ExQ1	Question to:	Question:
<b>1. General and cross-topic questions</b>		
Q1.1.1	The applicant	<p><b>Consultation on National Policy Statements</b></p> <p>The Government published on 24 April further consultation on each of the National Policy Statements (NPS) EN1, EN-3 and EN-5. The consultation period closed on 29 May 2025. Please advise if there are any areas of these documents that you consider the ExA should regard as important or relevant to the consideration of the proposed development.</p>
Q1.1.2	The applicant	<p><b>Assessment of environmental effects</b></p> <p>Noting the 40-year operational life of the proposed development, have its effects been assessed as temporary or permanent?</p>
Q1.1.3	The applicant	<p><b>Grid Connection</b></p> <p>The <a href="#">changes to the grid connection process</a> introduced by Great Britain's National Energy System Operator on 8 December 2025, mean that projects are prioritised where they are aligned to national energy targets and are ready-to-build, such as those with planning permission or land rights. As a result, energy generation projects have been informed of whether they are among the 283 GW of projects that will move forward now.</

Location of Geophysical Survey and Trenching
Figure 11.2c

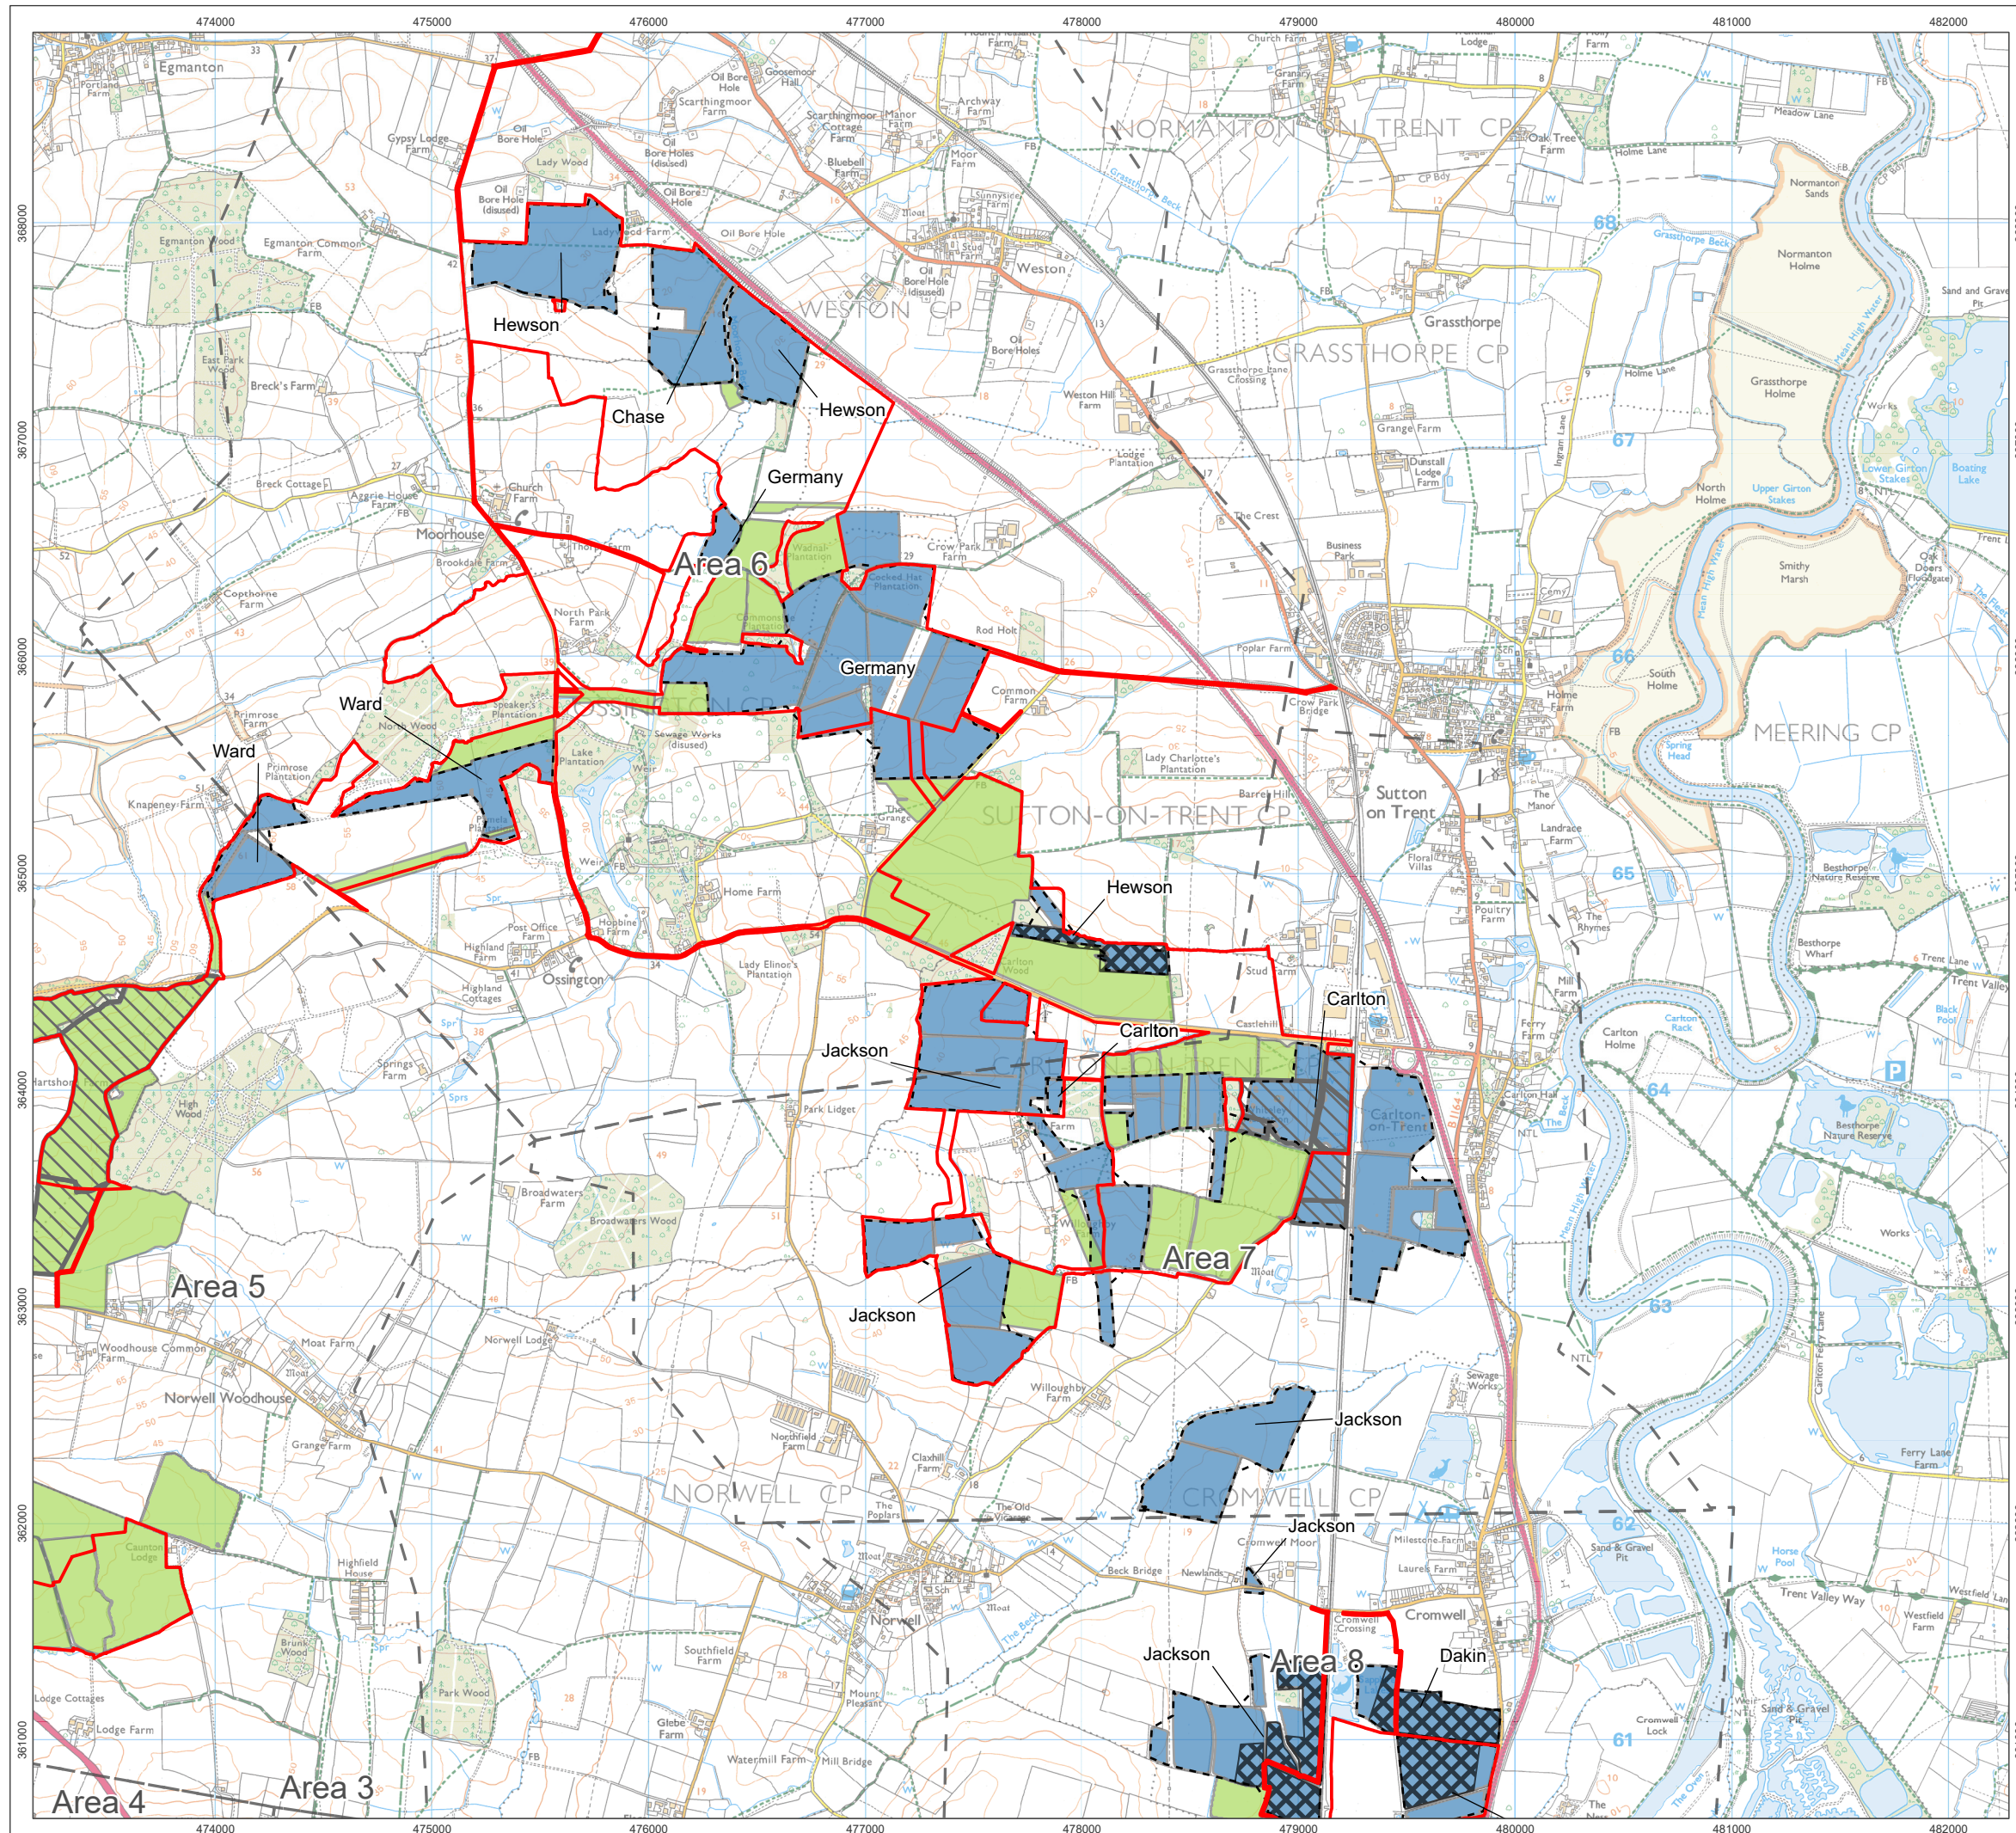
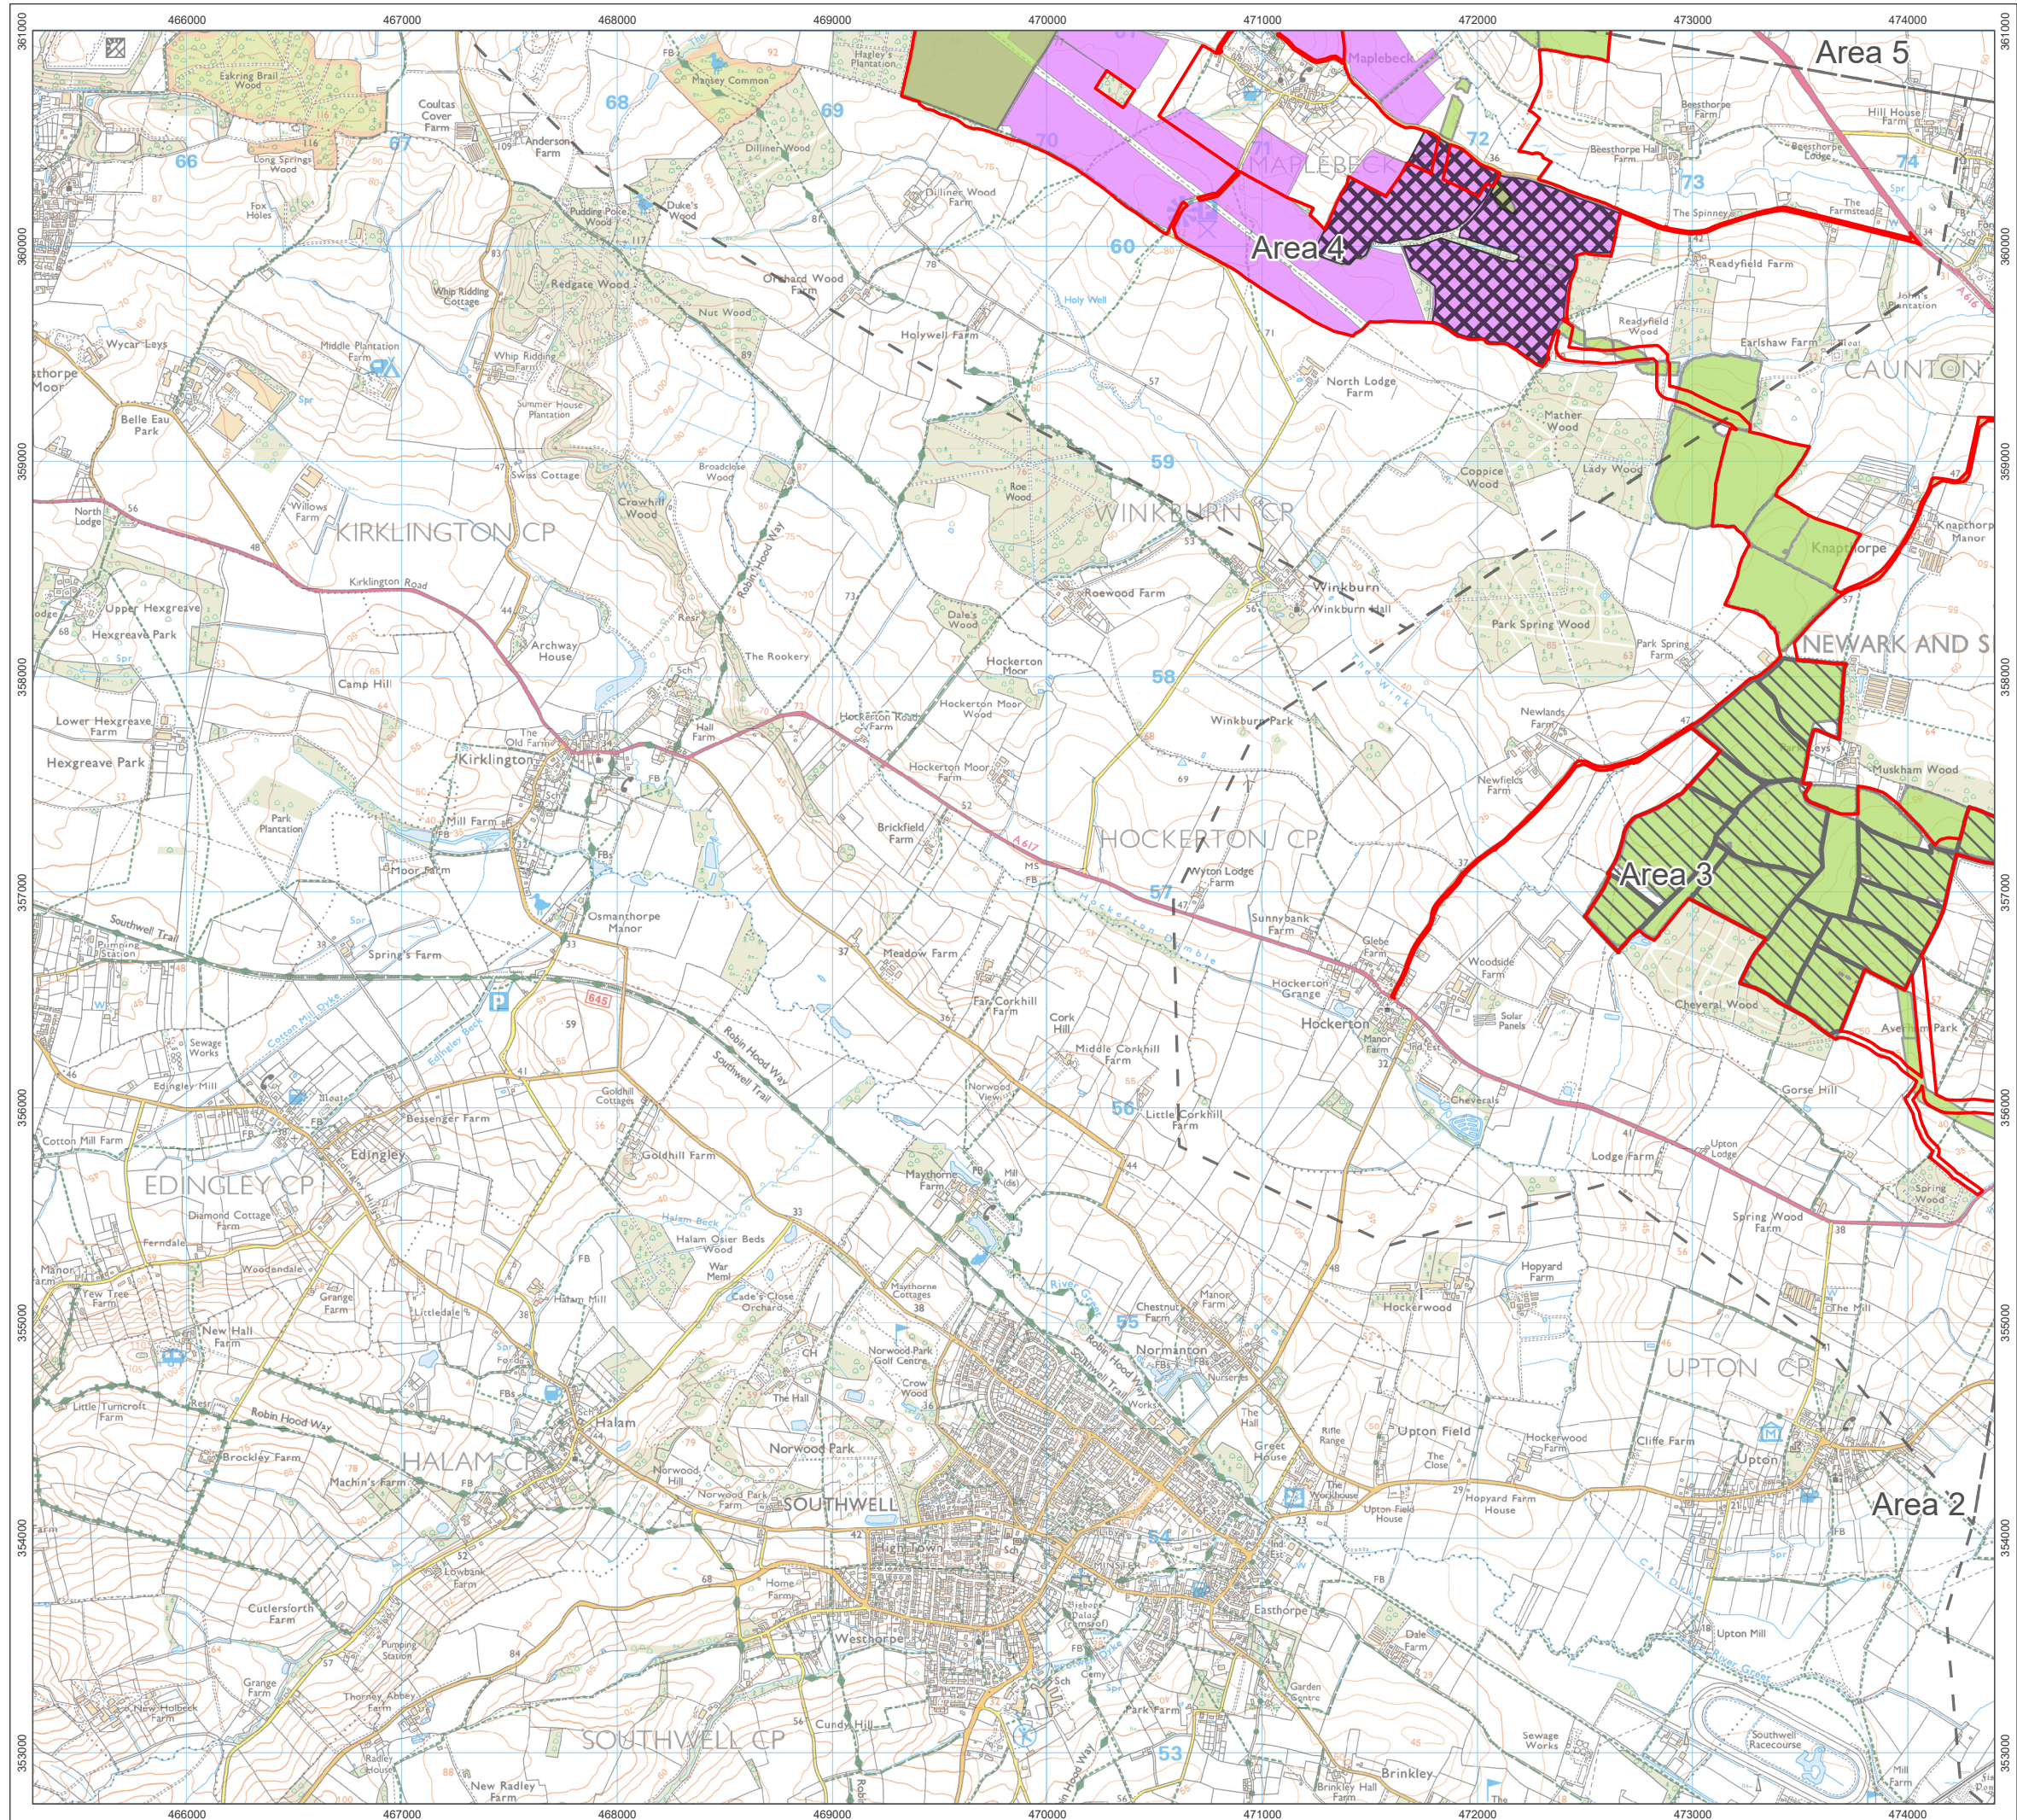
Q8.1.5	The applicant	<p><b>Phase 1 Geophysics Results</b></p> <p>The Technical Appendix A11.4: Phase 1 Geophysics Results <a href="#">APP-257</a> section 2.1 and section 5.2 set out that the survey area covers 542ha.</p> <p>However, the ES Chapter 11 <a href="#">[APP-054]</a> section 11.6.2.5 para 95 sets out that the phase 1 geophysical Survey covered approximately 1,837 ha and the Phase 2 Geophysical Survey covers 515 ha. Please clarify this discrepancy.</p>
Q8.1.6	The applicant	<p><b>Phase 1 Geophysics Results</b></p> <p>Section 9 of the Technical Appendix A11.4: Phase 1 Geophysics Results <a href="#">APP-257</a> sets out preliminary conclusions including reference to anomalies represent an extensive multi-period archaeological landscape, some of which are classified as ‘Unknown Features’ whose archaeological origins cannot be excluded. The outline Archaeological Mitigation Strategy <a href="#">[APP-269]</a> para 35 also states that the results of these surveys were used to inform the design of the development.</p> <p>Could the applicant please clarify specifically how the design of the development has responded to the survey findings.</p>

Q8.1.7	The applicant	<p><b>Phase 2 Geophysics Results</b></p> <p>Section 1.1 of Technical Appendix A11.5: Phase 2 Geophysics Results <a href="#">[APP-258]</a> sets out that this is an interim report and that the geophysical survey commissioned was over an area of approximately 635ha, though the report covers an area of around 515ha.</p> <p>The survey area for this stage of the project consists of 78 previously unsurveyed land parcels measuring (c. 635ha) located north of Ossington, east of Kersall, west of Maplebeck and north of Averham (Figure 1-4).</p> <p>The applicant is asked to please clarify how these areas were identified? Why was the full 635ha not covered and, of this area, which areas were excluded?</p>
Q8.1.8	The applicant	<p><b>Phase 2 Geophysics Results</b></p> <p>The conclusions of the Phase 2 Geophysics Results <a href="#">[APP-258]</a> at section 8.0 set out a number of findings, including that the survey identified three main areas of archaeological activity within the survey area. These areas comprise anomalies indicative of probable cut features, containing anthropogenically enhanced fill. The features include ditched enclosures, ring ditches, former field systems, and discrete pits. These anomalies appear to form Iron Age/Roman/British enclosures with associated field systems. Other more-isolated anomalies have also been interpreted as possible/probable archaeological origin.</p> <p>What are the consequences/implications of these findings?</p>
